339-D-009001

Barclay Avenue Lot Division  
Project Name/Description

Memorandum  
Department of Planning and Development  
Planning Division

Re: Barclay Avenue Three Lot Subdivision, vicinity 35 Barclay Avenue  
APPENDUM #1

Figure No. 3

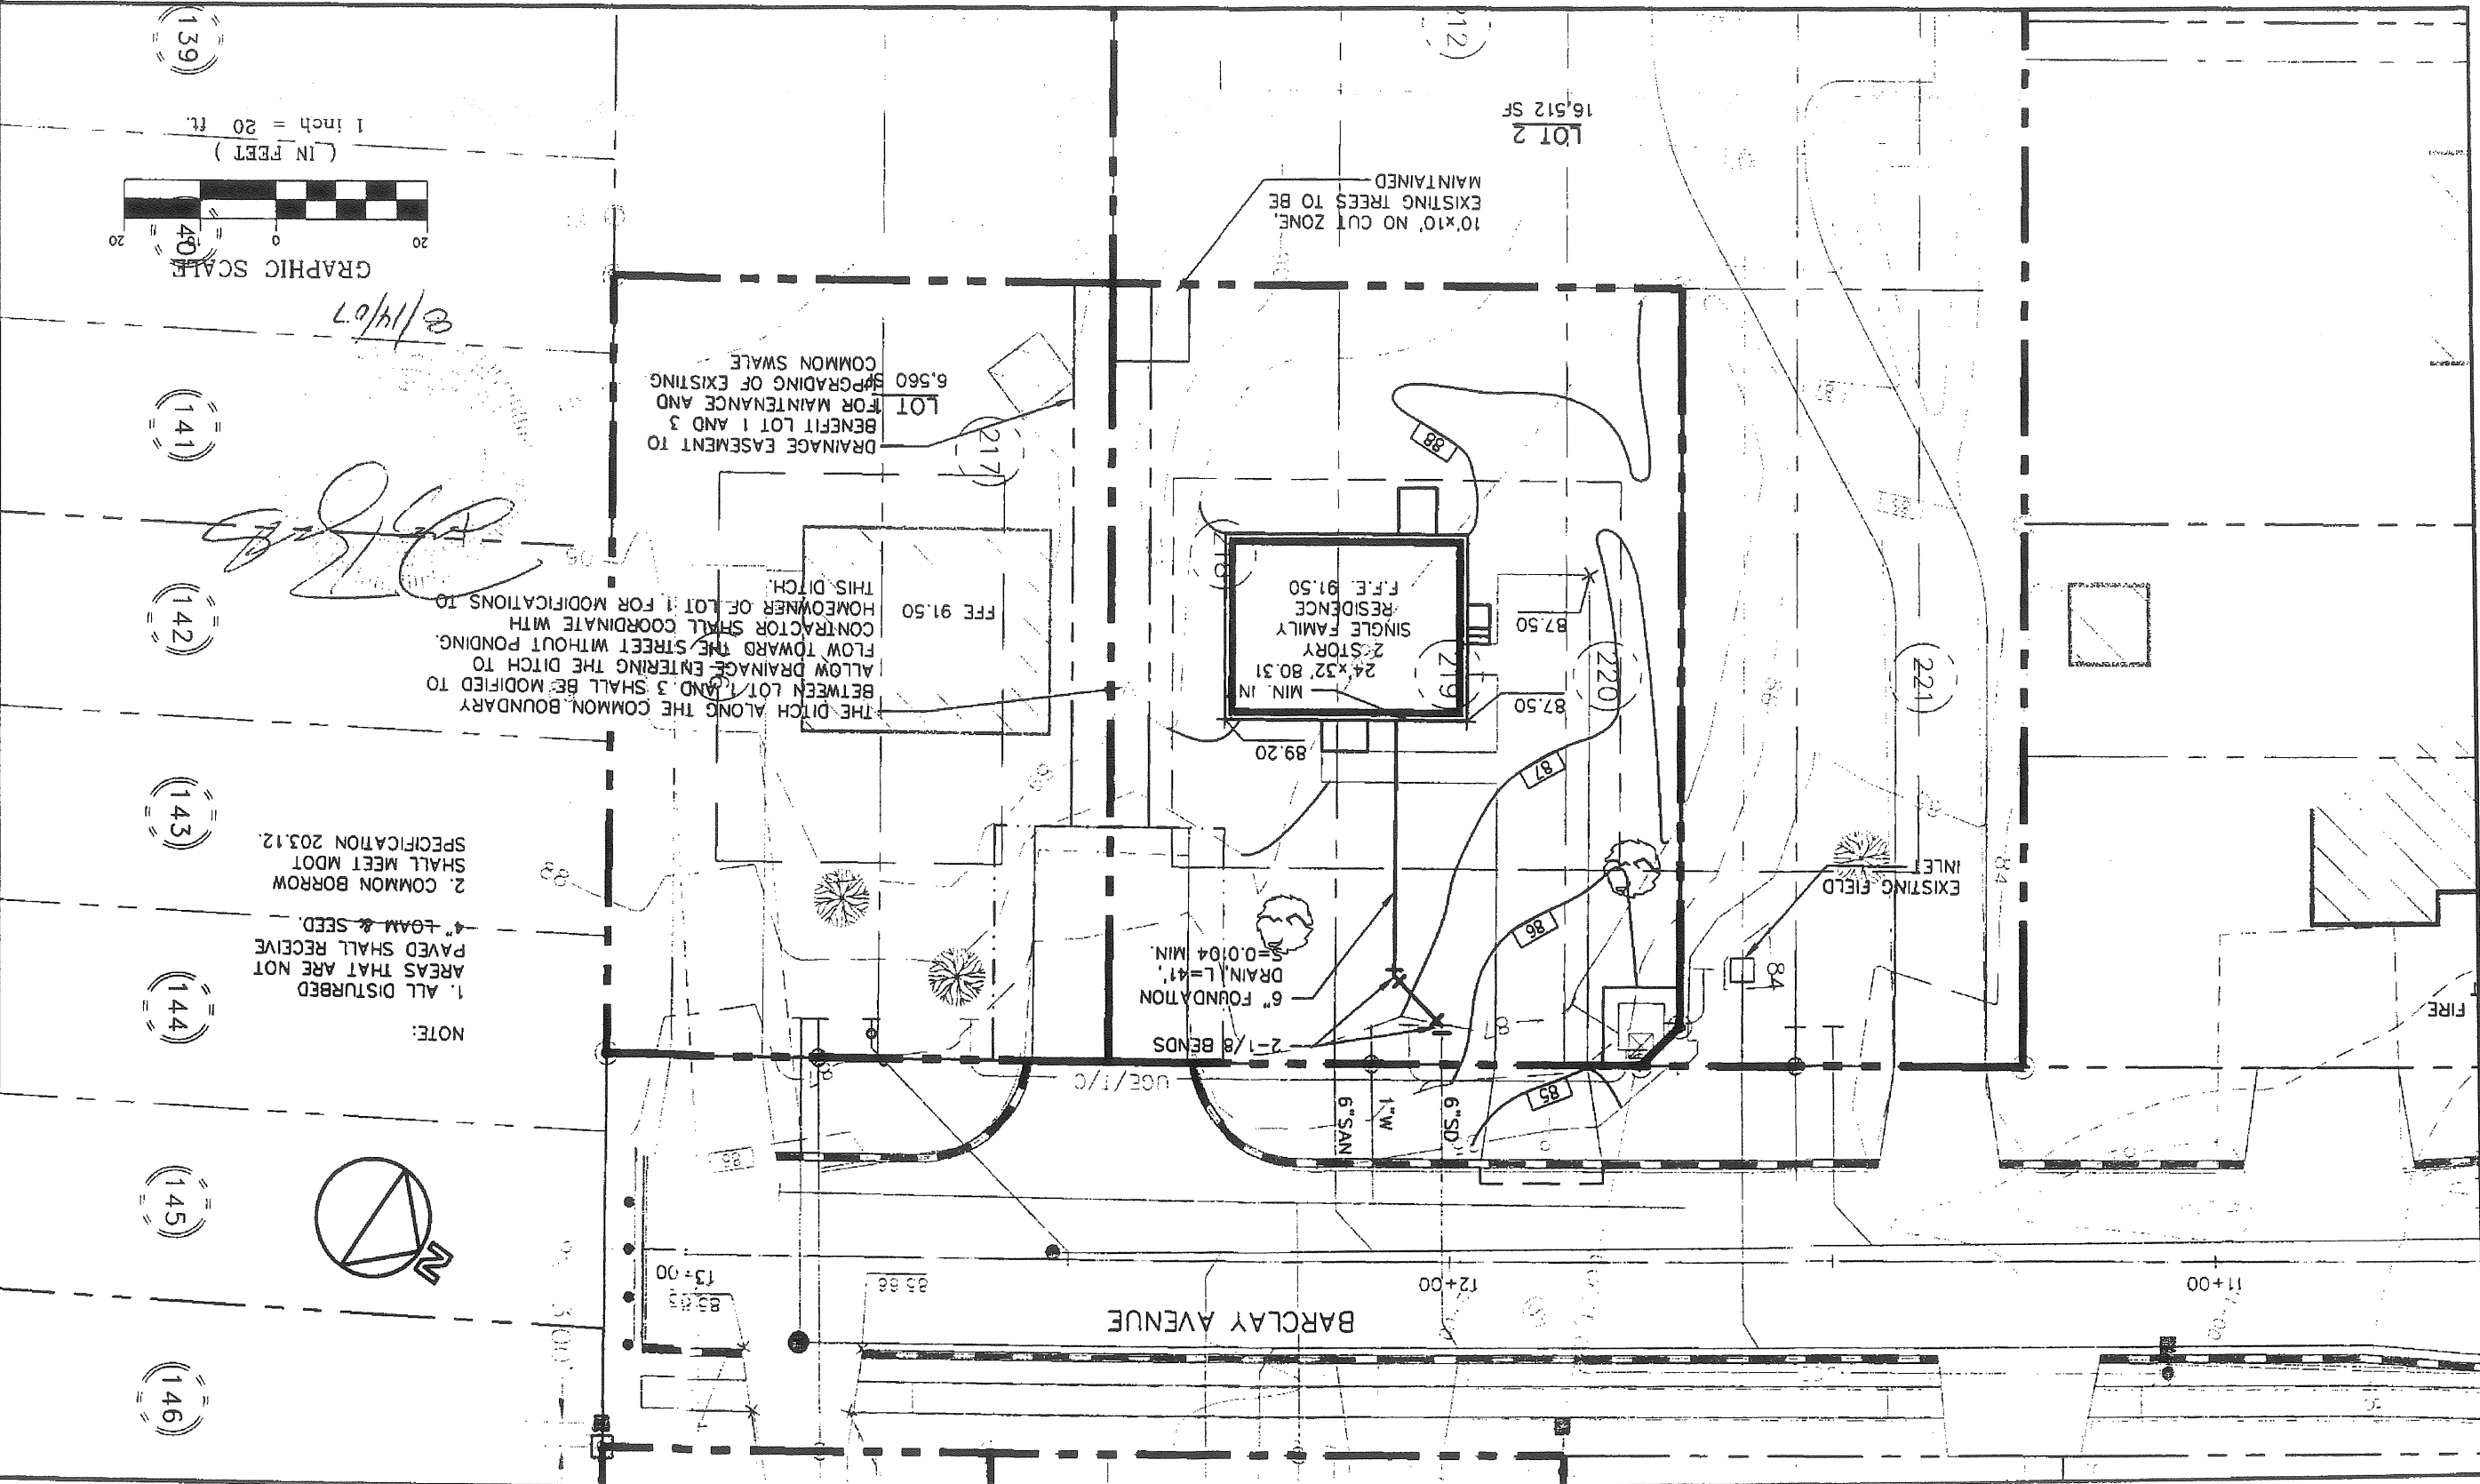
- ii. The applicant shall present evidence of a satisfactory drainage easement in respect of Lot 2 (field inlet) for final review and approval by Corporation Counsel, and provide additional easement(s) for review and approval if determined appropriate; and

- iii. The applicant shall secure, submit for review and approval by Corporation Counsel, and show on the Subdivision Plat, an executed construction easement for the ditch area between Lots 1 and 3; and

- iv. In the event one or both of the easements referenced in conditions ii and iii are not secured, the applicant shall submit, for review and approval prior to the registration of the Subdivision Plat, revised grading plans that ensure all storm water remains on Lot 3; and

1. I have had recent discussions (on 6/8/2007) with Jim Wolf and his Engineer, Doug Reynolds, regarding the grading and drainage issues and the swale/ditch line that already exists on my property at 39 Barclay Avenue. As you are likely aware, there has been a significant amount of back and forth on these issues. The City Engineer, Dan Goyette, has commented that there is a high spot on my lot that "prohibits runoff from the rear of Lot 1 and potentially Lot 3 from enter the ditch line and flowing out to the street" (5/29/2007 memo).

Based on this recommendation, I do still have some concerns about possible drainage issues and wet areas that I may experience as a direct result of the new structure to be built at 35 Barclay Avenue. I would like to note that since I moved into the house at 39 Barclay in 2003, I have had water issues on that side of my lot on a regular basis. For example, after heavy rains, it takes a considerable amount of time for the water to flow out to the street. In addition, after a recent spring storm, I noticed that – due to the extra moisture in the earth – the concrete blocks on one side of my shed have sunk into the ground. For these reasons, I can only surmise that the situation will not be improved by the addition of another house next door.

1) A condition that requires the developer to remedy any possible future drainage/water issues on the right-hand side of my lot abutting the site to be developed. In addition, I would also like to make certain that the builder/developer is required to correspond with me regarding any changes he/she plans to make to the existing ditch line.
